**MP10\_0057 MOD2 132 – 138 Killeaton Street St Ives**

I refer to your email of 11 October 2011 requesting comments from the Office of Environment and Heritage (OEH) on the revised document titled 'Management Plan for Post-Construction Permanent Basement Pump Out' for the residential development at 132 – 138 Killeaton Street St Ives.

**MP10\_0057 132-138 Killeaton Street St Ives - MOD2 Modification to Condition C35 (a) and (b)**

**Attachment A****MP10\_0057 132-138 Killeaton Street St Ives - MOD2 Modification to Condition C35 (a) and (b)**

HYDROGEOLOGICAL PLAN

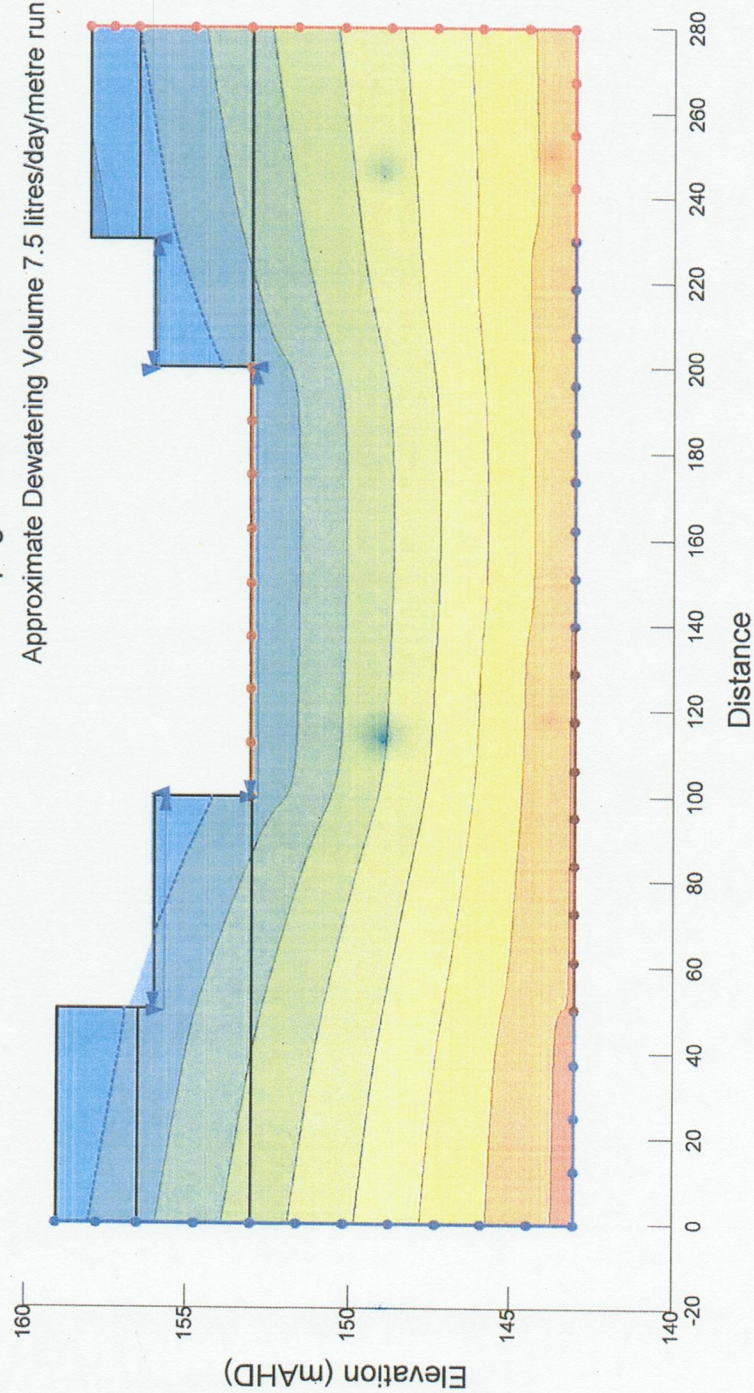
I note that the hydrogeological assessment report states that the effects of waterproofing the perimeter upper basement walls reduces the total inflow only marginally, however it has not provided any evidence or examples of where full basement tanking has been ineffective. The current requirement is to build a fully tanked structure, not just to waterproof the walls. Given that tanking is required on other similar developments, the proponent should clarify whether it is suggesting that full tanking is ineffective before the modification is further considered.

The hydrogeological assessment estimates that the groundwater inflow rate into the proposed basement will be approximately 2,500 – 4,000L per day. The report suggests that the flow rate may decrease once the excavation has drained the local area, as there is limited catchment over which surface water can feed the groundwater, as the site is located on the crest of a hill. However, the report does not consider the possibility of spring fed groundwater.

In order to amend conditions as proposed, the proponent should further investigate the nature of groundwater flows at the site and whether dewatering the above volume of groundwater would impact on groundwater dependent ecosystems located in Garigal National Park or elsewhere downstream of the development site.
